Subject: Submission Details for

SSD 6011 - Mixed use residential development within the South West Plot

26 July 2013

Winter Solstice 1pm

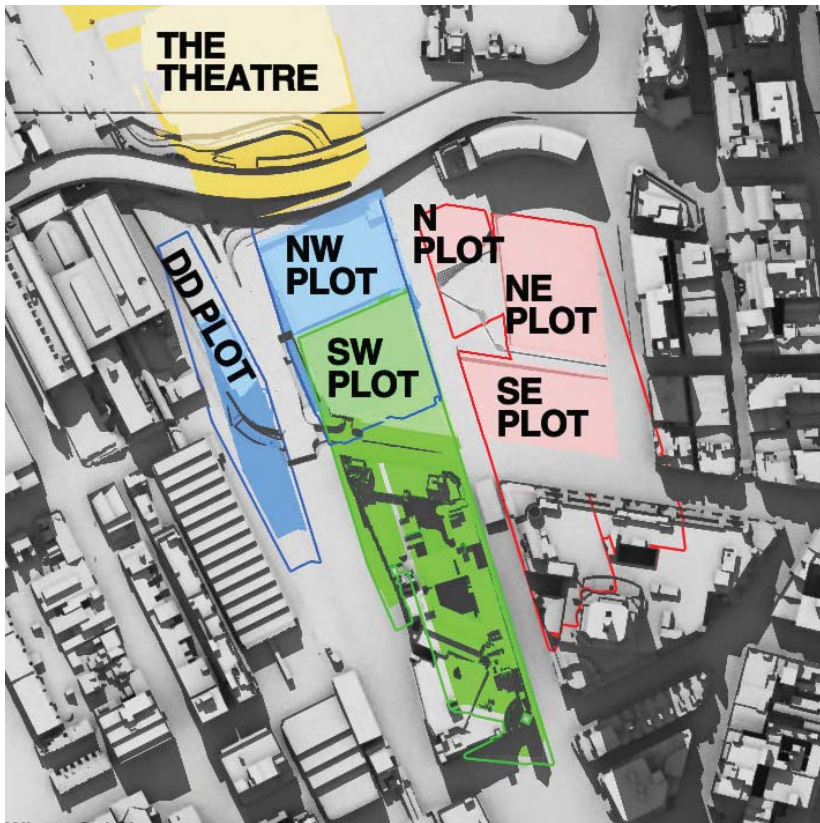
At 1pm the existing shadowing has been substantially removed, but not totally removed.

At 1pm the existing shadowing has been substantially, although not entirely, removed. However, overshadowing of lower levels of the west façade by the concept proposal parameter plan shadows for the N,NE and SE plots has already started.

Winter Solstice 3pm

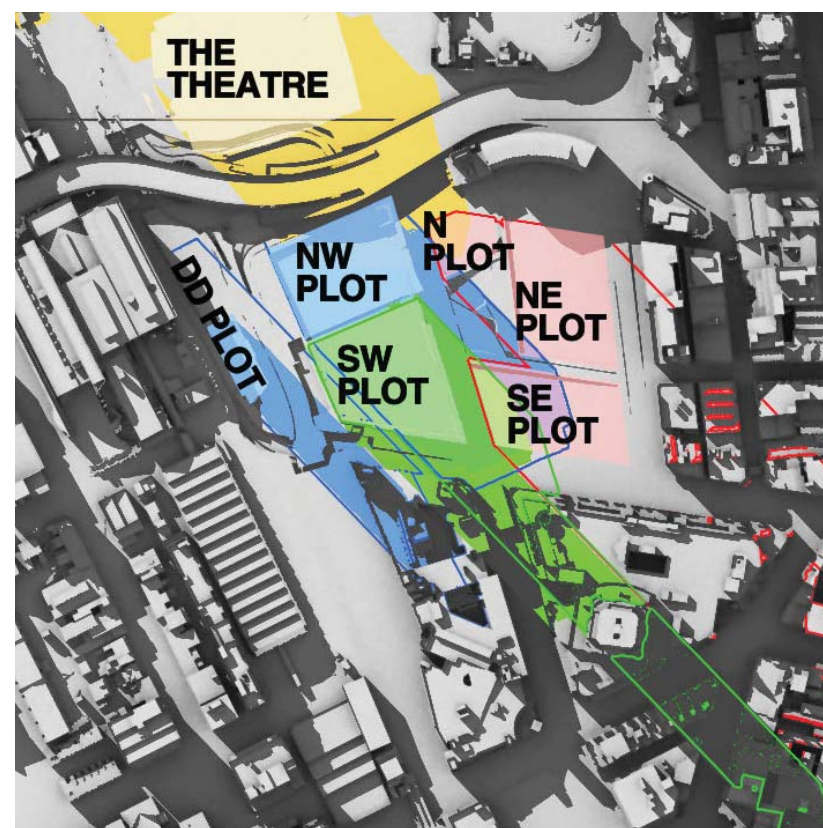
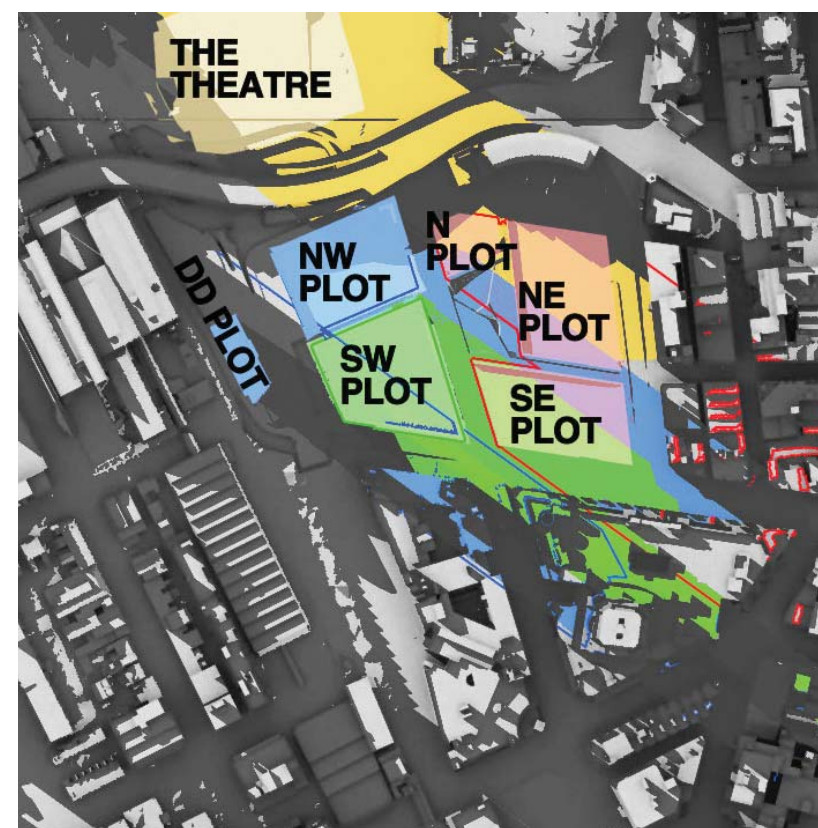
We refer to the shadow diagrams in SSD5878, Appendix H. Supplementary Design Report, Section 6. Amendments, Winter solstice - 22 June. This is not 21 June, but there would be no noticeable difference.

At 9am, 10am and 11am the west façade is totally in shadow due to other parts of The Peak building itself.

At 12pm there is still substantial existing shadowing on the west façade caused by the irregular shape of the west facade.

It can be concluded that some single aspect apartments on the west façade and some south-west dual aspect corner apartments currently receive less than 2 hours direct sunlight to habitable rooms and 50% of the private open space between 9am and 3pm on 21 June.

By 2pm the existing shadowing has been totally removed, but that is too late to achieve two hours of direct sunlight before 3pm.

At 9am, 10am and 11am the west façade is totally in shadow due to other parts of The Peak building itself.

At 12pm there is still substantial existing shadowing on the west façade caused by the irregular shape of the west facade.

By 2pm the existing shadowing has been totally removed. However, overshadowing of the west façade by the SSDA4 and SSDA5 buildings has appeared and risen further up the west façade than the concept proposal parameter plan shadows for the N,NE and SE plots, which is still present.

At 3pm, the proponent states correctly that 45-45% of the western façade is overshadowed by the SSDA4 and SSDA5 buildings.

It can be concluded that, as a result of combination of the proposed development with existing shadowing of the west façade, some single aspect apartments on the west façade and the south-west dual aspect corner apartments which currently receive less than 2 hours direct sunlight to habitable rooms and 50% of the private open space between 9am and 3pm on 21 June will suffer additional overshadowing. It is beyond our skills to count the number of such apartments. We note that the proponent has made no attempt to do so.

Rather than counting the number of units which will not meet the DCP guidelines, the proponent attempts to trade-off direct sunlight at 4pm for lack of direct sunlight during the period 9am to 3pm. There is no provision in the DCP guidelines for such a trade-off.
